CITY OF ALBUQUERQUE

August 21, 2017

**RE: Del Webb @ Mirehaven Phase 2A
Grading & Drainage Plan Revision 4
Engineer's Stamp Date 3-11-16 (Rev. 4 Date: 08/17)
Hydrology File: H09D017F**

DESIGN REVIEW COMMITTEE	CITY ENGINEER APPROVAL	LAST DESIGN UPDATE	MO./DAY/YR.	MO./DAY/YR.
CITY PROJECT NO.		ZONE MAP NO.	SHEET	OF
			7	7

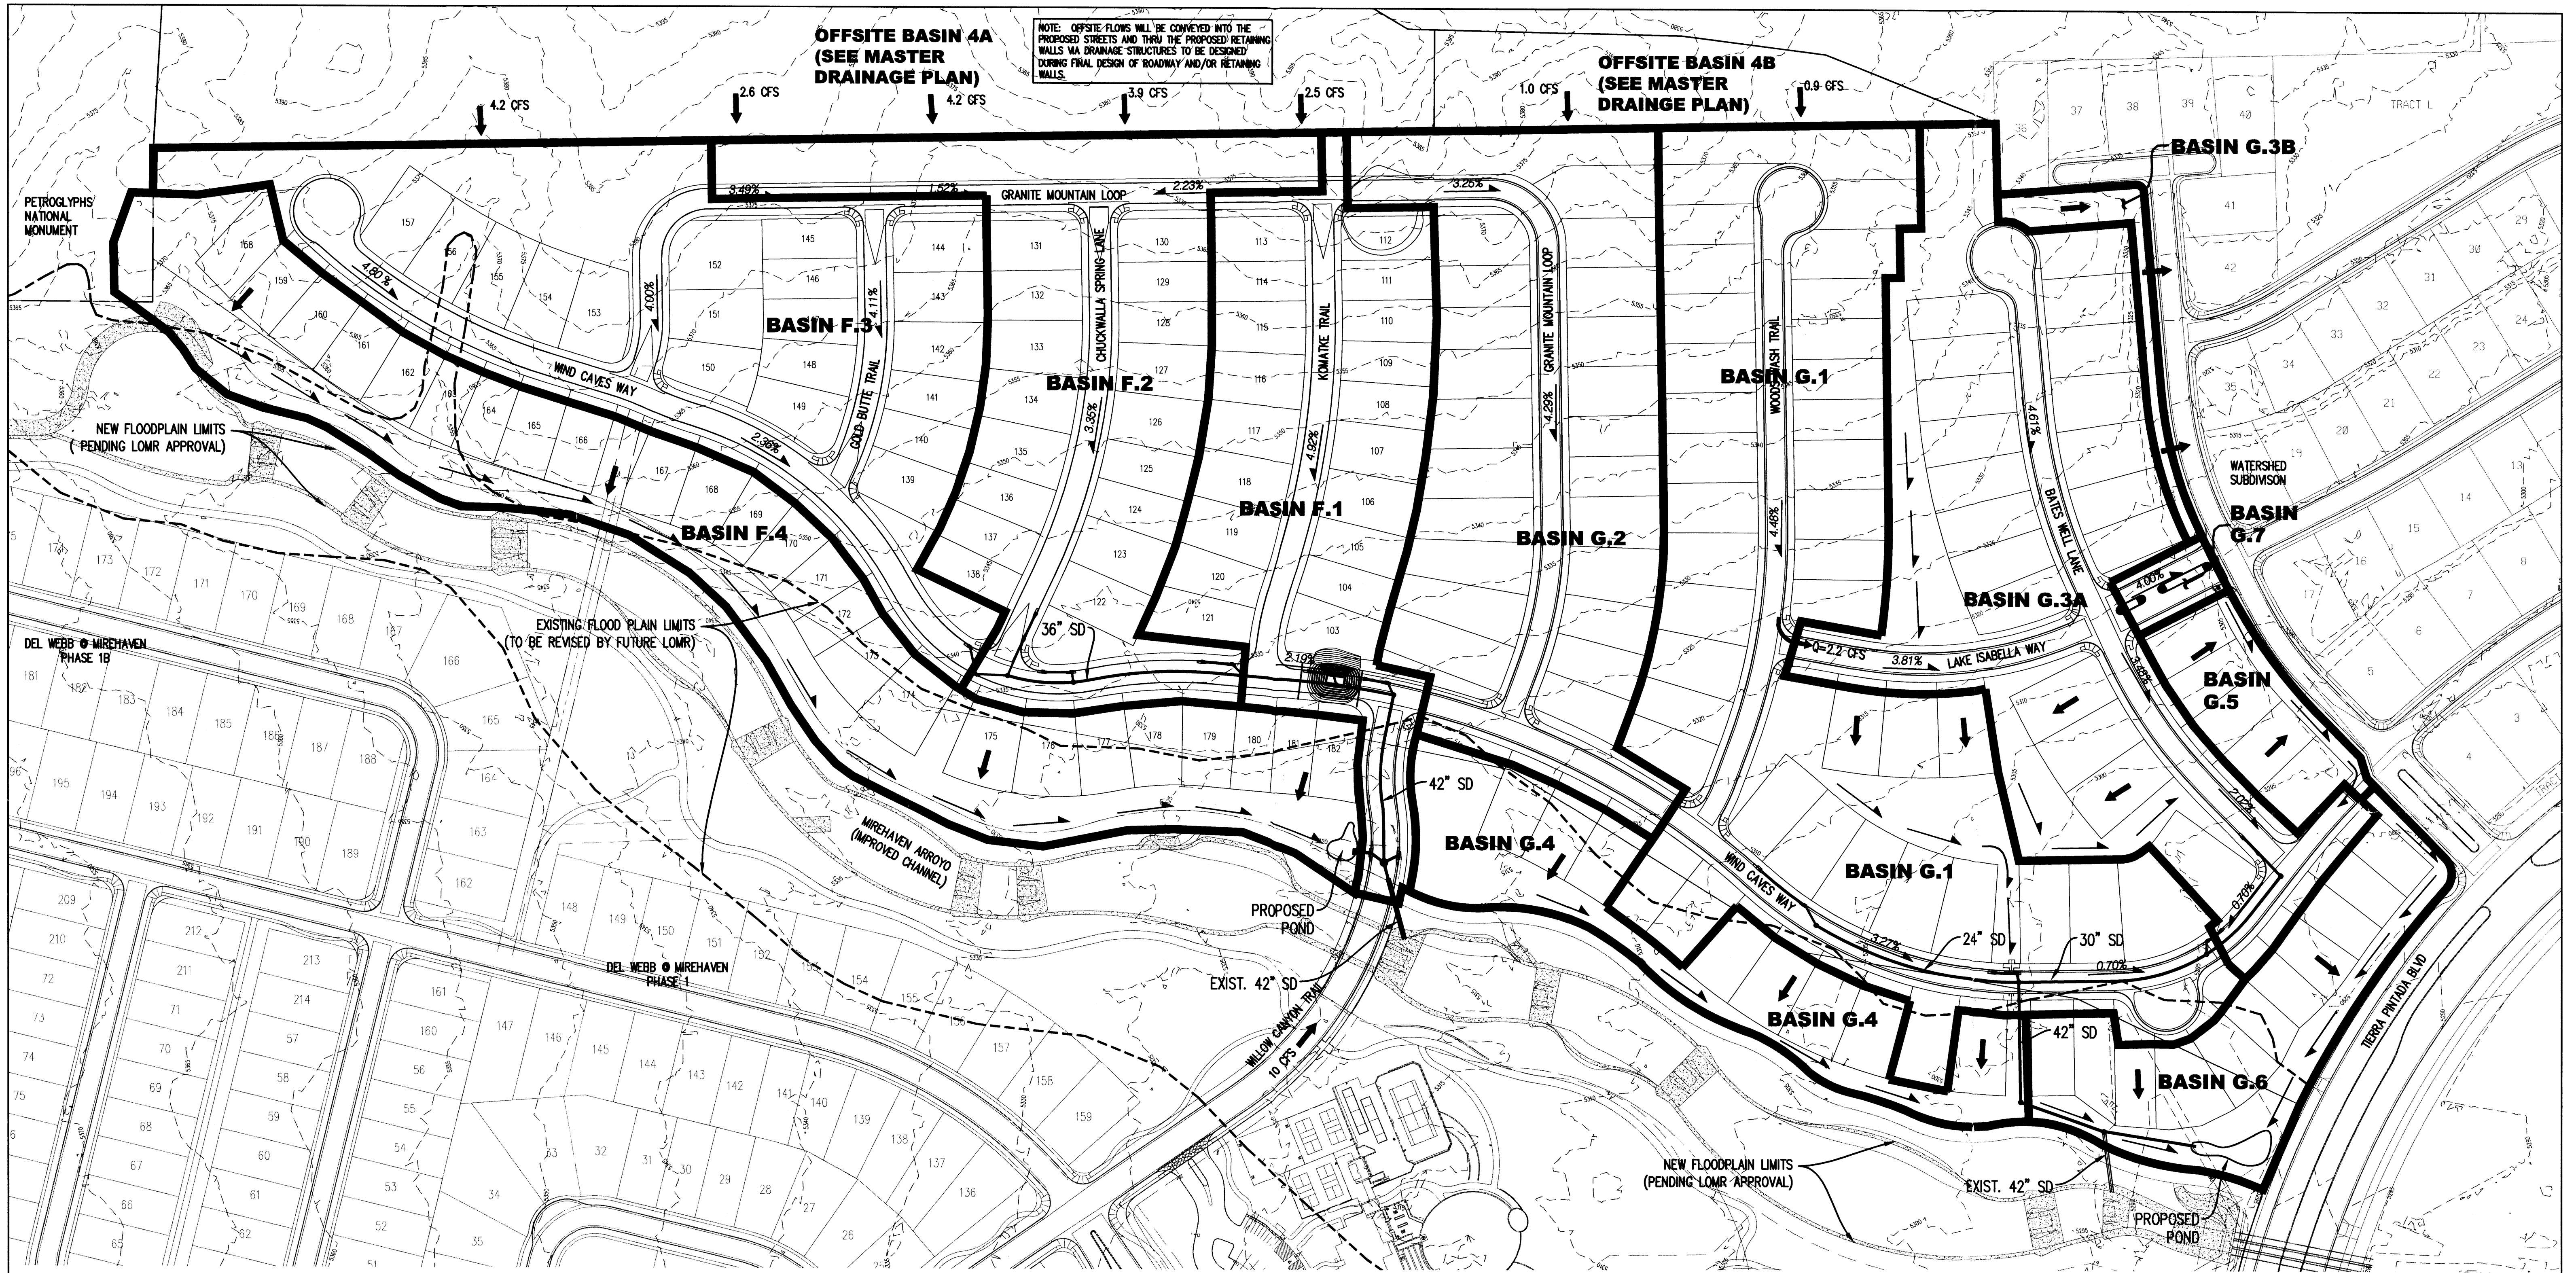
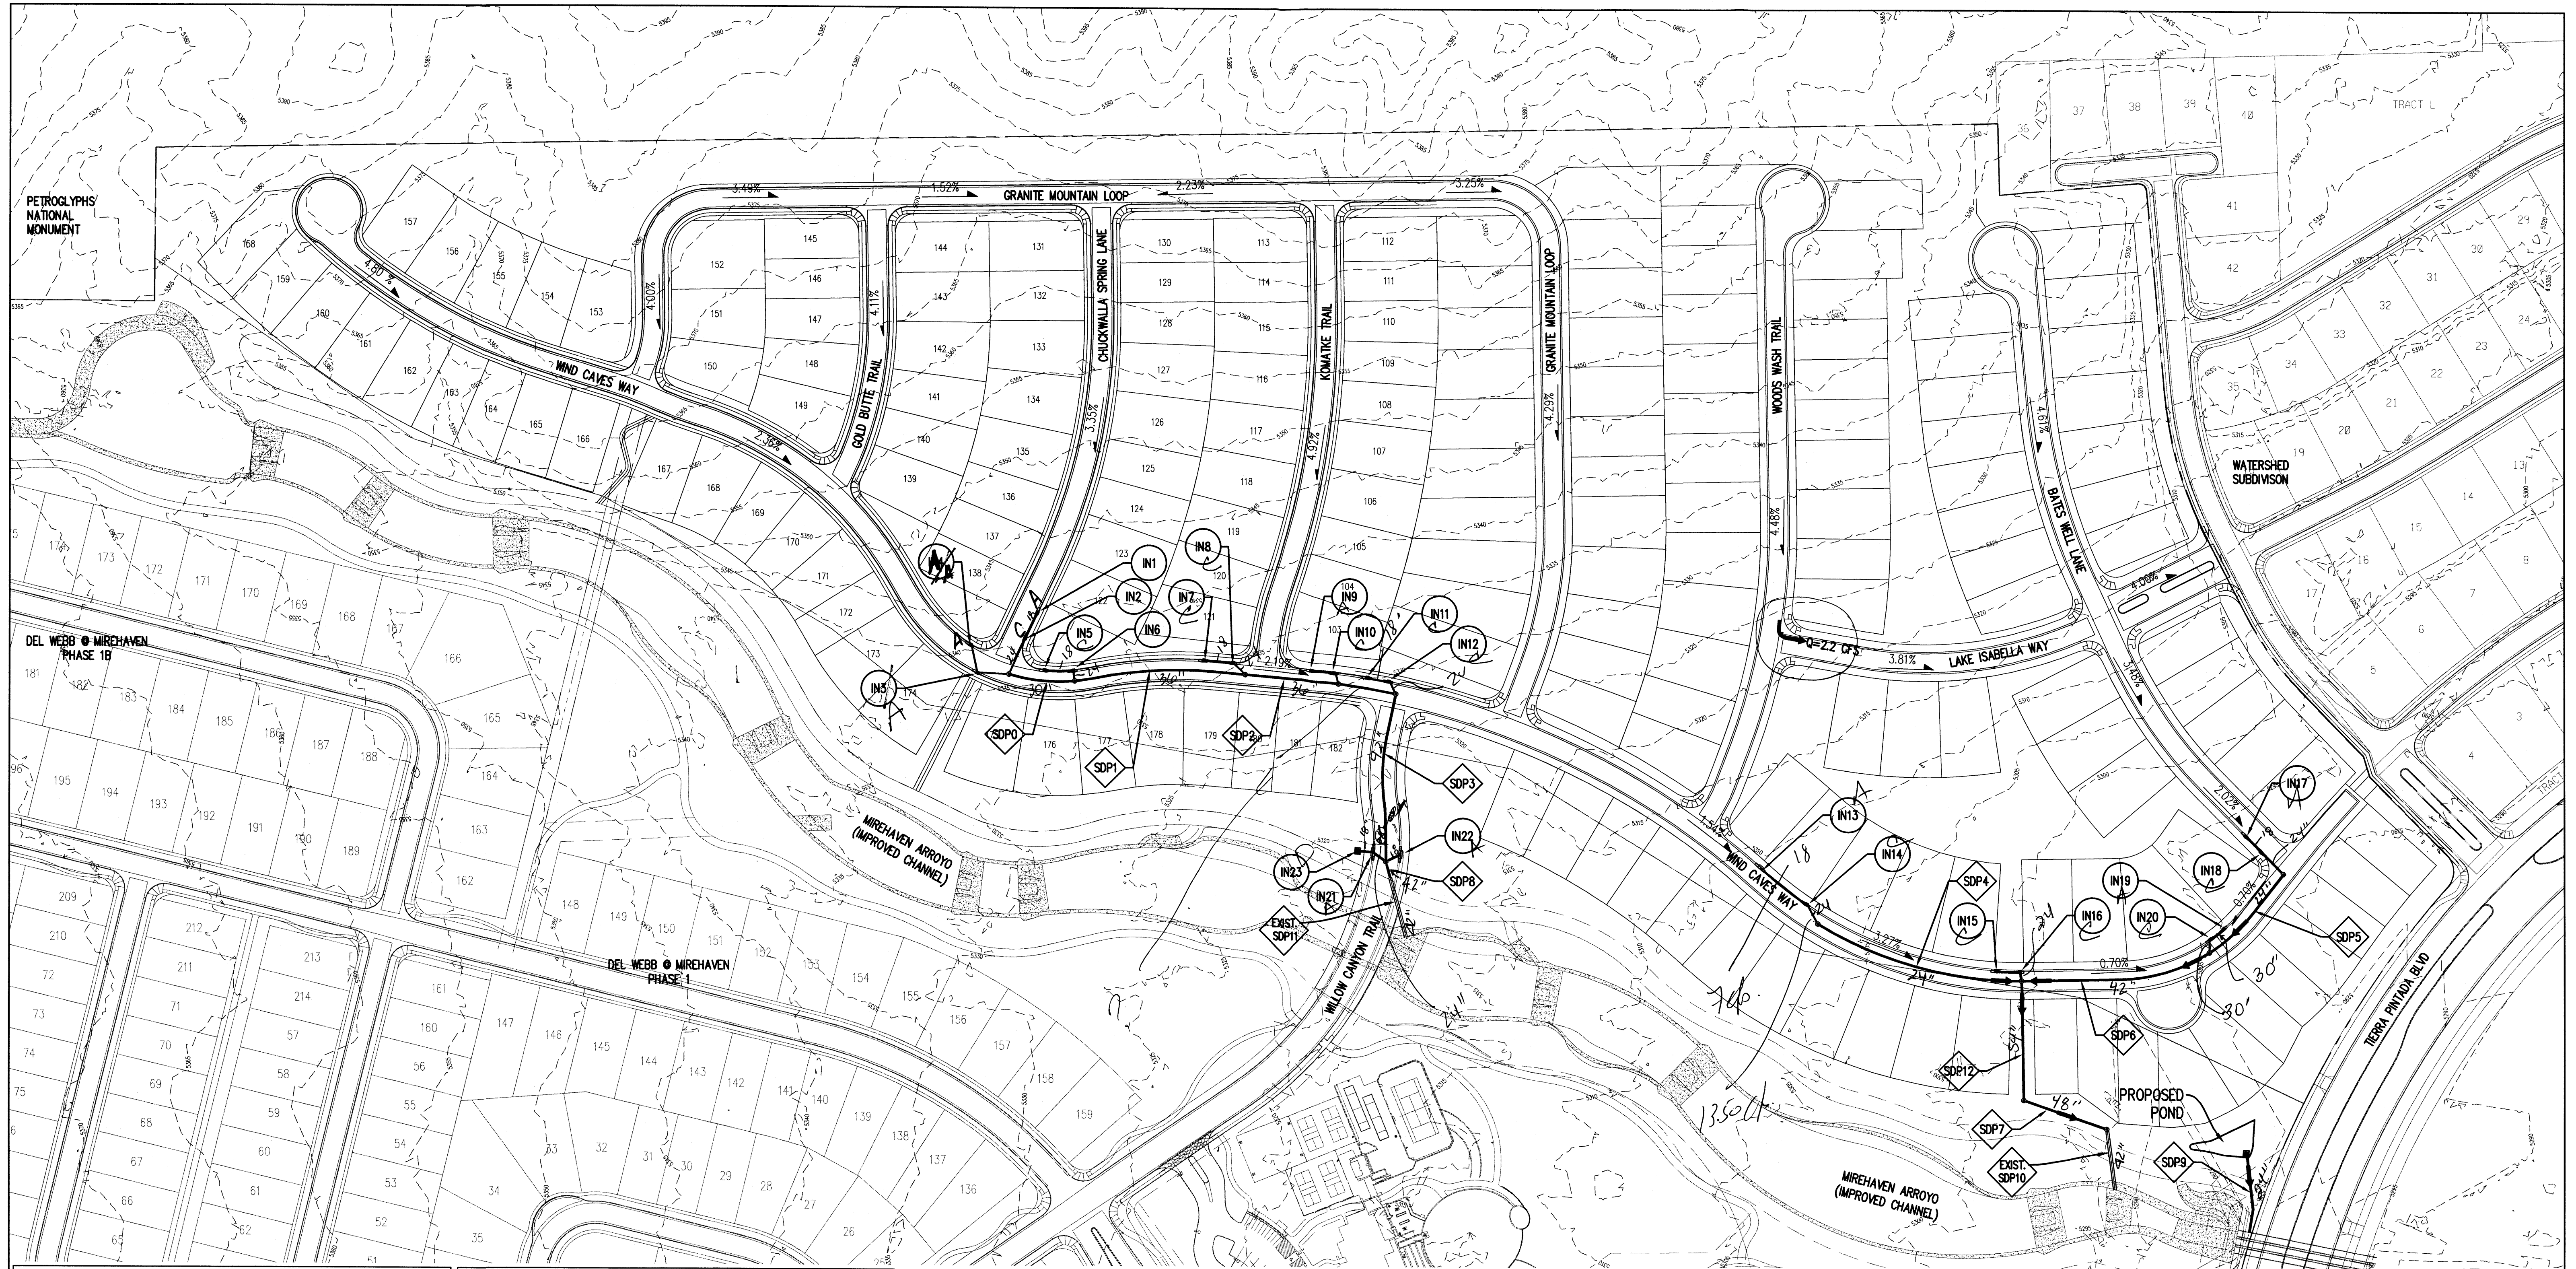
1. An Engineer Certified Addendum to the Drainage Report is required to support the new drainage pattern. The following should be addressed:
 - a. Proposed Basin Map: Basin G.5 will now drain into G.6
 - b. Geometry and hydraulic capacity of the new swale adjacent to lot 22.
 - c. Hydraulic capacity of the swale behind lots 16-22, accounting for the additional flow from G.5. This swale may need to be upsized.
